Section 75W to Project Approval (MP10_0050)

Westmead Millennium Institute, Westmead Health Campus

Submitted to Department of Planning and Infrastructure
On Behalf of Westmead Millennium Institute for Medical Research

September 2013 ■ 13254

NORTH ELEVATION

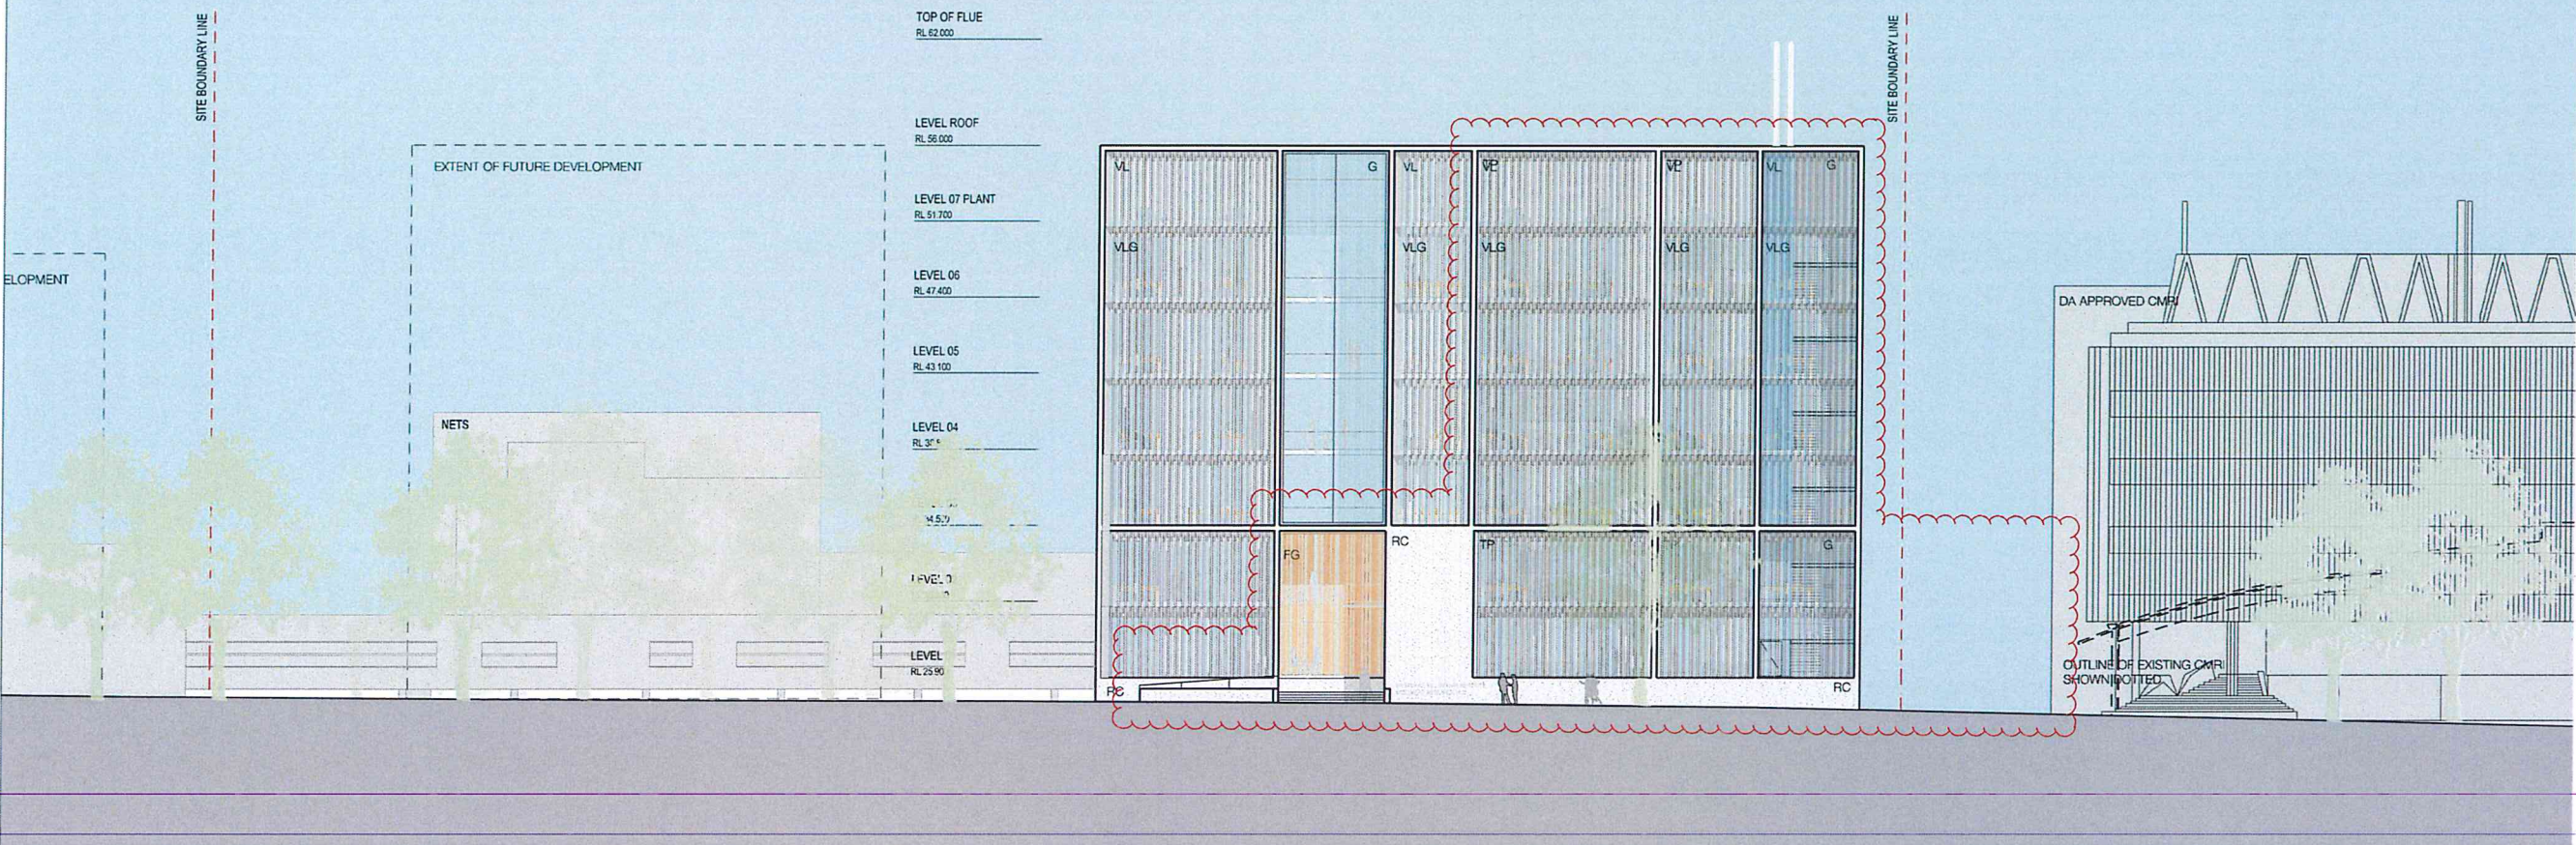
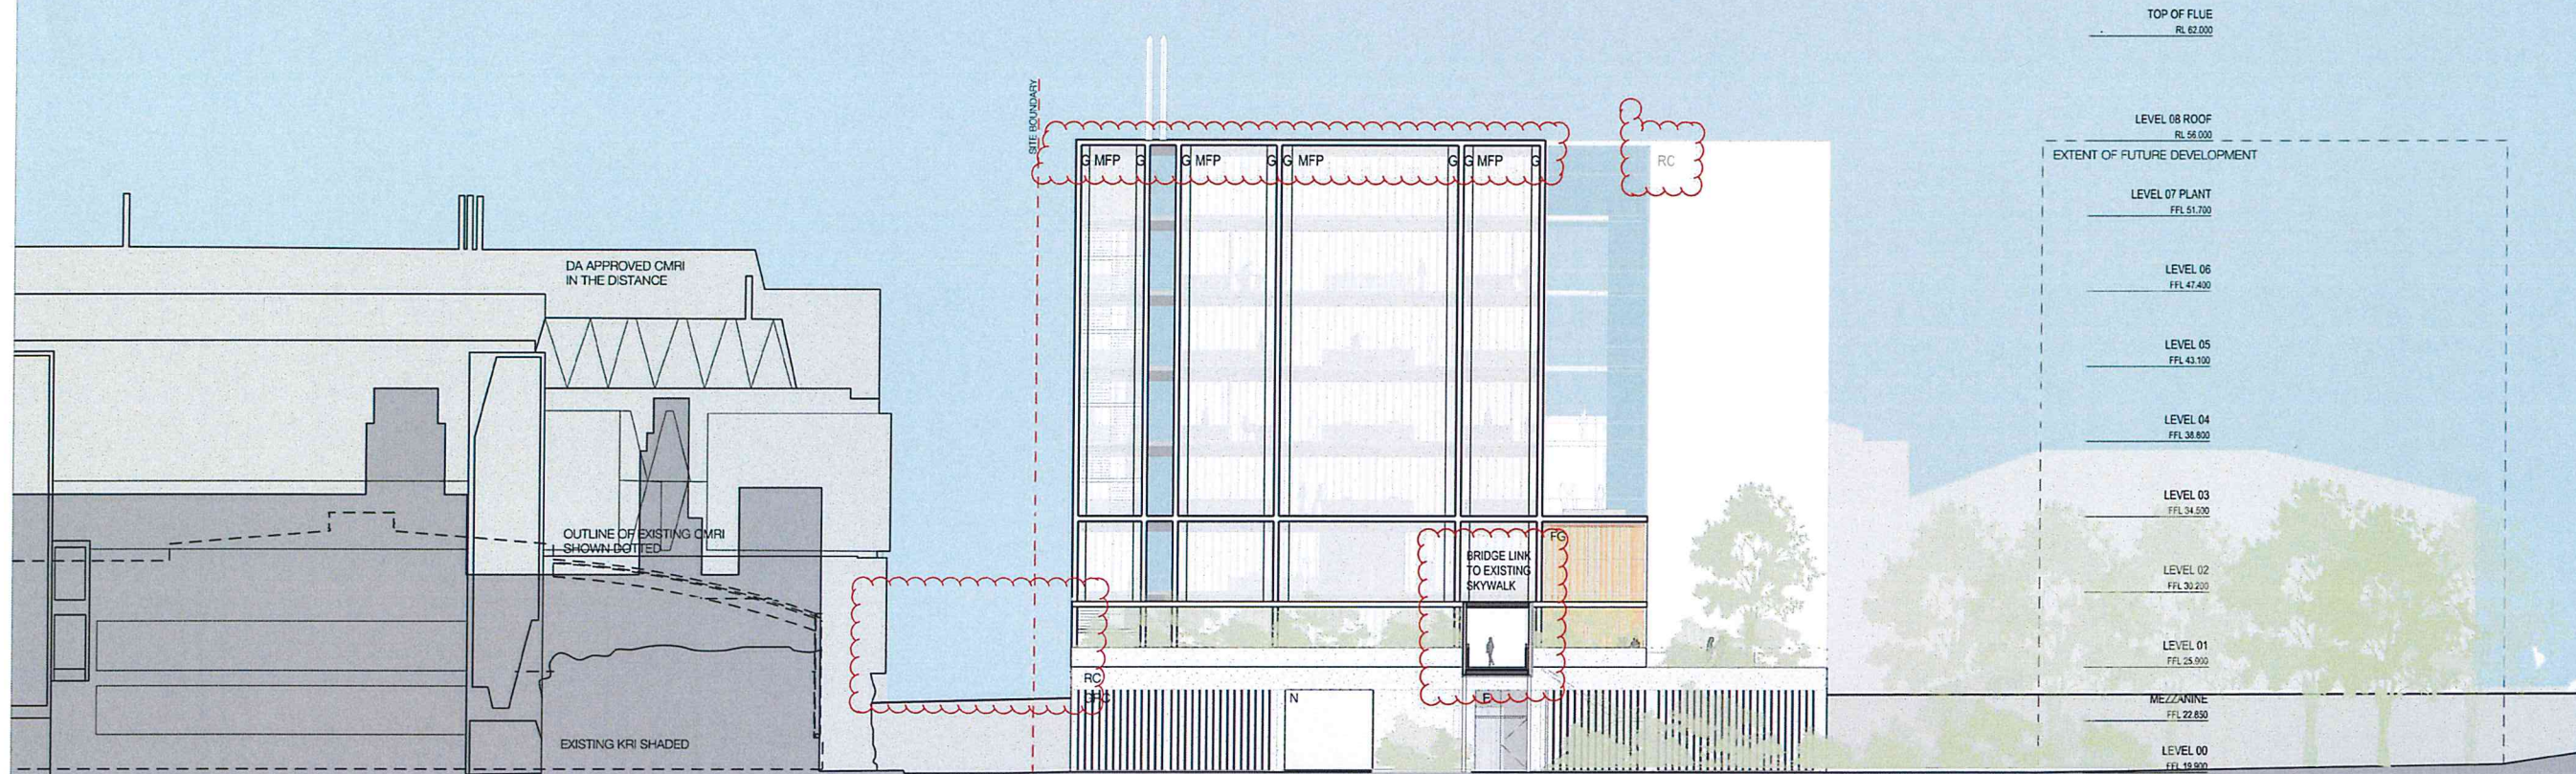
North elevation:

- Translucent facade panels have been changed to solid facade panels to suit internal functional arrangements
- Extent of vertical louvres and external glazing reduced
- Within the Setback area the previous vertical louvres and glazing have been replaced with a solid concrete wall
